M54 to M6 Link Road

**Review of Proposed Habitat Creation
on Land Owned by Allow Ltd.**

September 2020

Quality Management	
Client:	Allow Ltd.
Project:	M54 to M6 Link Road
Report Title:	Review of Proposed Habitat Creation on Land Owned by Allow Ltd
Project Number:	ECO-5912
File Reference:	5912 EcoReview dv4
Date:	25/09/2020

Plot Date: 10 December 2019 13:05:11
File Name: \\UK632\p\sw001\1\1\1\ENVIRONMENT\Practice Areas\GIS\Projects\M54\M6 Link\Workspace\Stage 3 Figures\Ecology\PO2 Template\HE514465-ACM-EGN-M54_SW_PR_Z-DR-EG-0038 - GCN Survey Results 2019.mxd

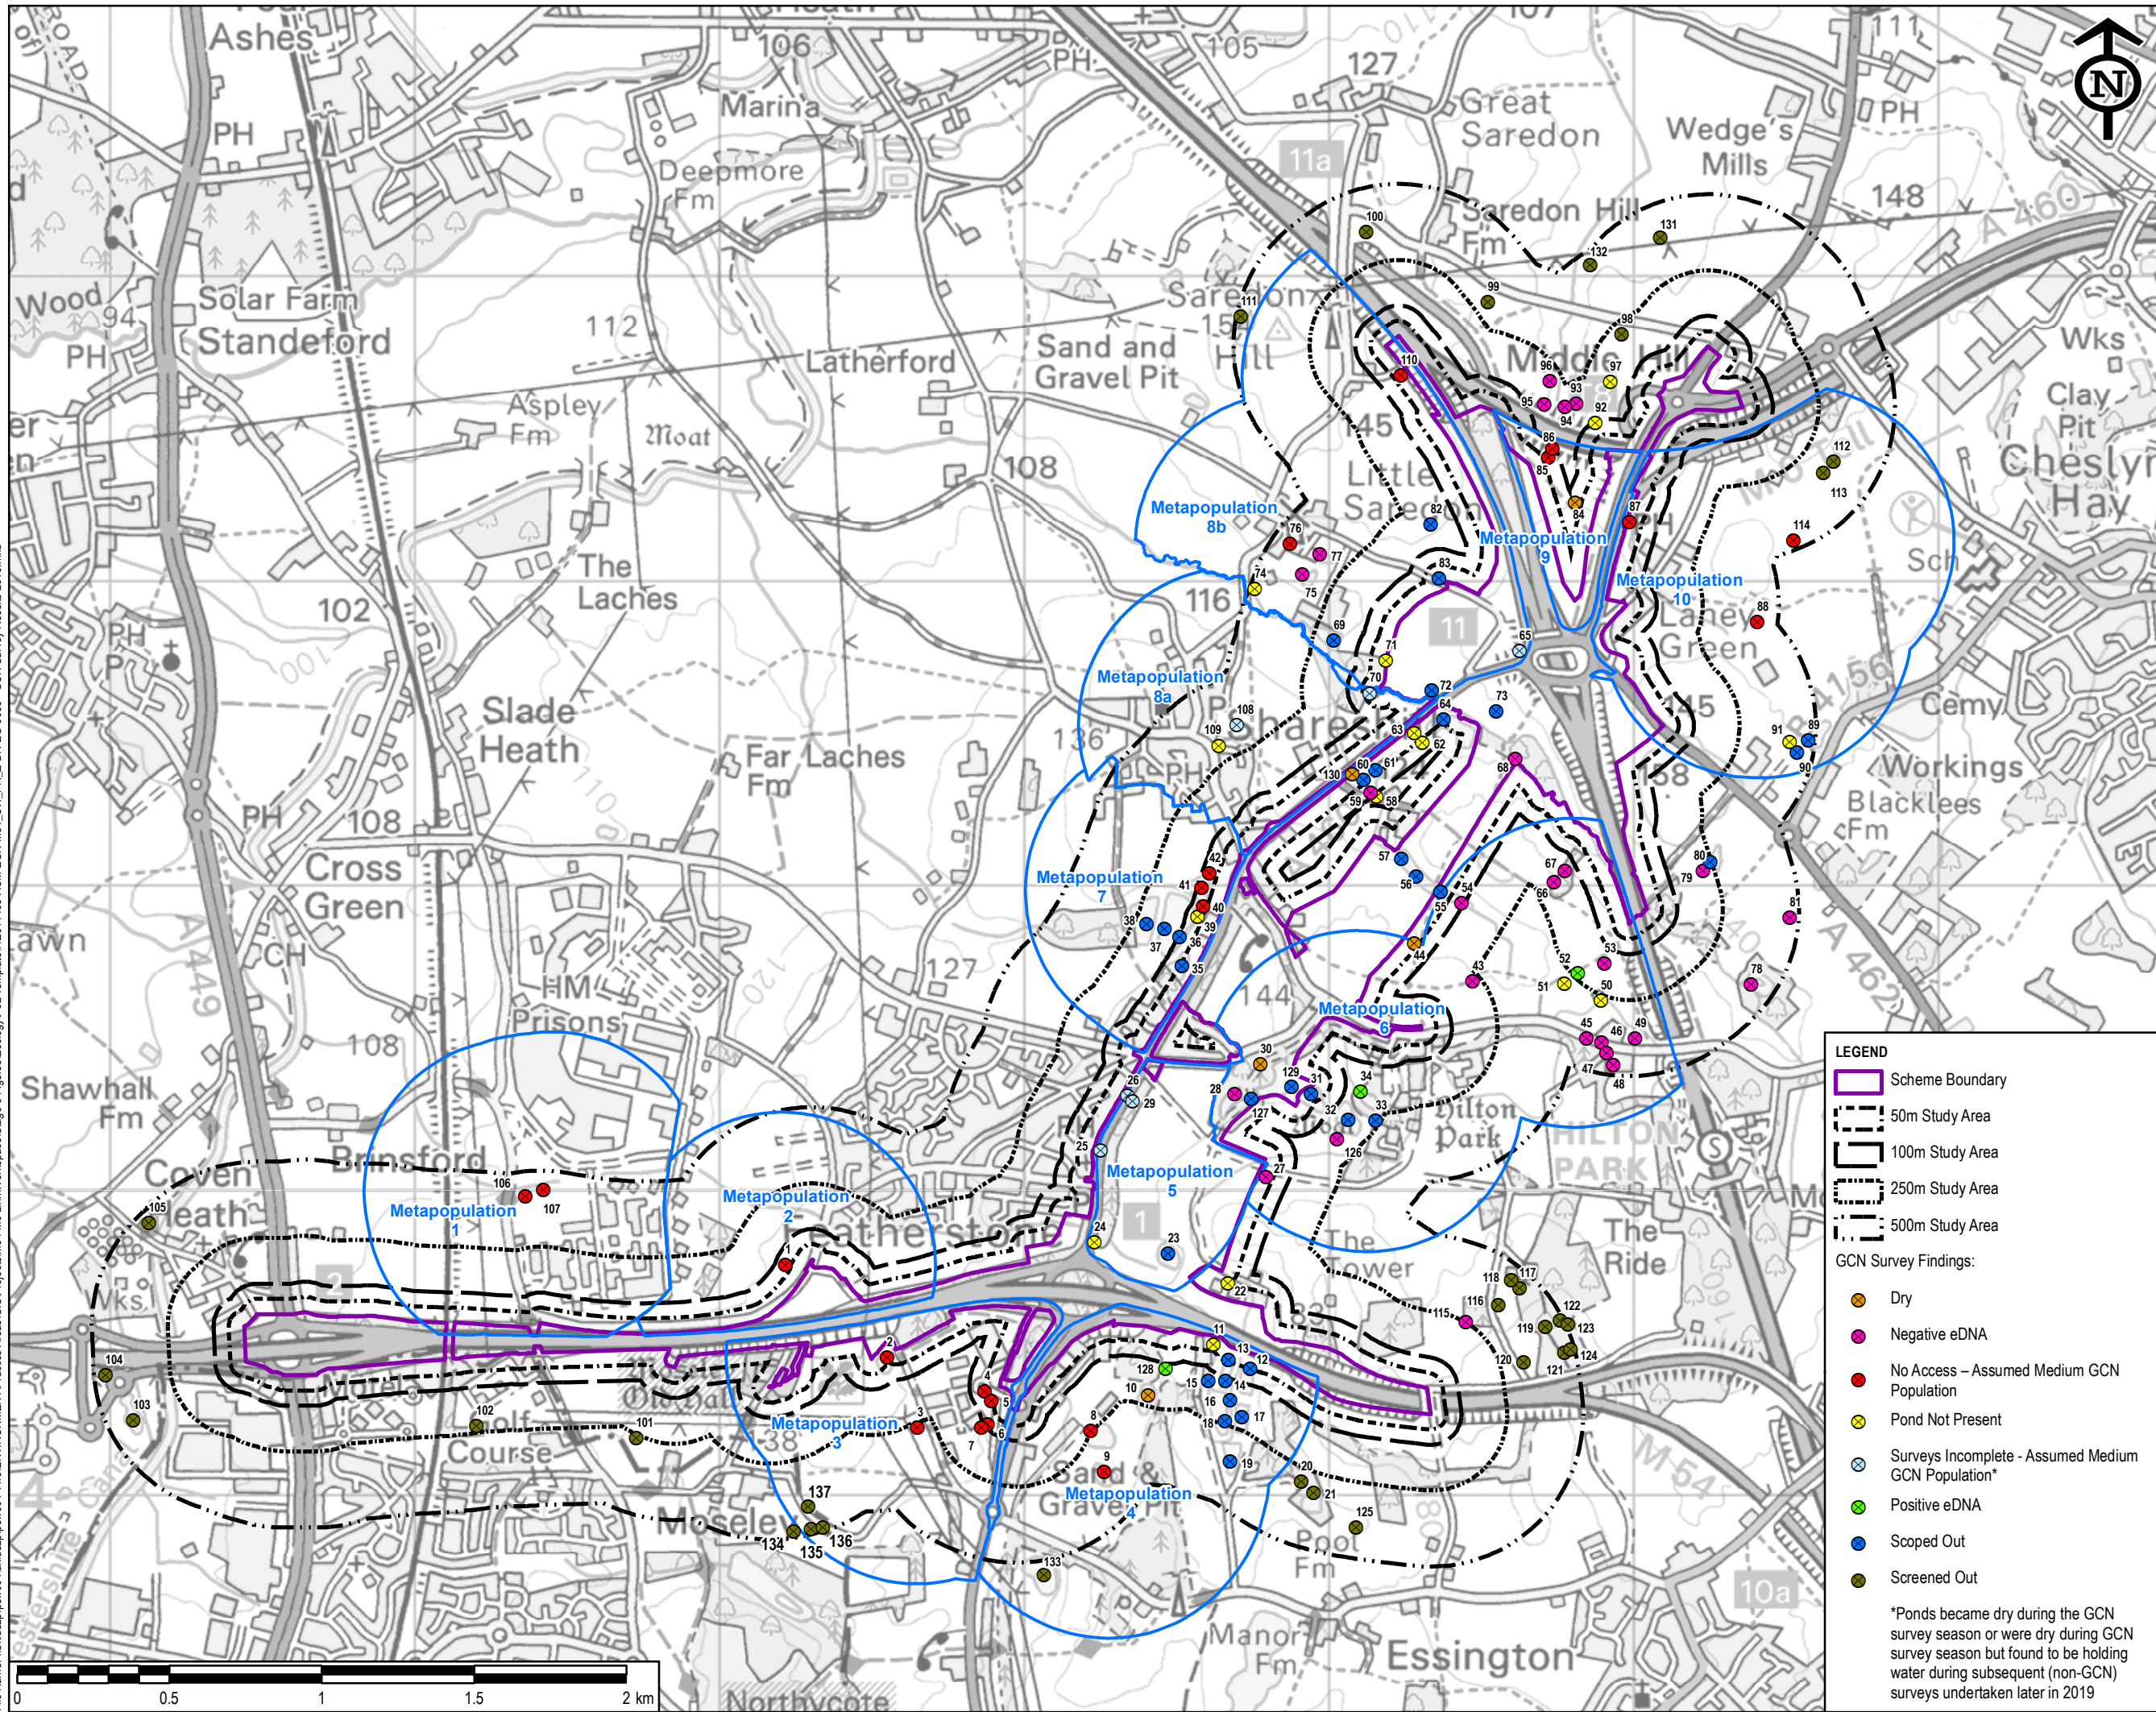
- 2.4.1 Four of the ponds being lost to the scheme (ponds 25, 26, 29 and 65) were not surveyed sufficiently during the baseline assessment as they were dry during the Habitat Suitability Assessment (HSI), but were later found to hold water in July (Table 4.2, Environmental Statement Appendix 8.11). However, they have been 'assumed' to support 'Medium' metapopulations (Metapopulations 5 and 8b - Table 8.20 Environmental Statement Chapter 8). The presence of these 'assumed' populations has guided mitigation and habitat creation proposals. However, if these estimates are over-inflated or, quite possibly based on the findings of surveys of surrounding ponds, the ponds do not support Great Crested Newts, then the habitat creation proposals would not be proportionate or appropriate (they would be excessive). Indeed, Figure 8.29 shows that the closest ponds to 25, 26 and 29 returned negative Environmental DNA (eDNA) results.

2.5.1 Figures 8.28 and 8.29 of the ES show that historic, and current, known presence of Great Crested Newt is greatest to the east of the proposed scheme. However, at least five of the proposed ‘ecological ponds’ will be created to the west of the scheme. Currently, due to the absence of survey data, the exact number of compensatory ponds required is unknown. In addition, based on the known local distribution of GCN being to the east of the scheme, the locations of the proposed ponds, and their ability to effectively contribute to Great Crested Newt conservation (and alleviation of predicted project effects) is inappropriate. New ponds would not link to existing populations of Great Crested Newts and hence would not serve to mitigate effects from losses to the scheme. This is particularly important for this species which has a population ecology that functions as a meta-population, typically requiring clusters of ponds for long term population success. This allows temporary losses of a population from an individual pond, for example due to an environmental event, to be recovered by colonisation by GCN from a nearby pond.

2.8.1 All background records for the species (Figure 8.28 of the ES) and ponds confirmed to support GCN (confirmed through eDNA surveys for the scheme – see ES Figure 8.29) are located to the east of the proposed scheme. As such, the appropriateness and effectiveness of creating compensatory habitat for this species to the west of the scheme is in question. If the location of compensatory ponds is inappropriate, then the current habitat creation proposals for land within 500m of these ponds (designed to benefit the species) should also be reviewed alongside proposed pond locations. This must all be based on up-to-date survey information⁶.

2.8.2 Ecology Ponds EP05 and EP06 are being provided for 'assumed' metapopulation 5a (although only metapopulation '5' is shown on Figure 8.29). However, this 'assumed' population, if present, is separated from the ponds by residential development and

2.5.2 It is recommended that the siting of mitigation is re-visited and this re-located to the east of the scheme.

2.6.5 It is recommended that the rationale for locating proposed ponds should be re-visited and consideration be given to relocating ponds to the east of the link road.
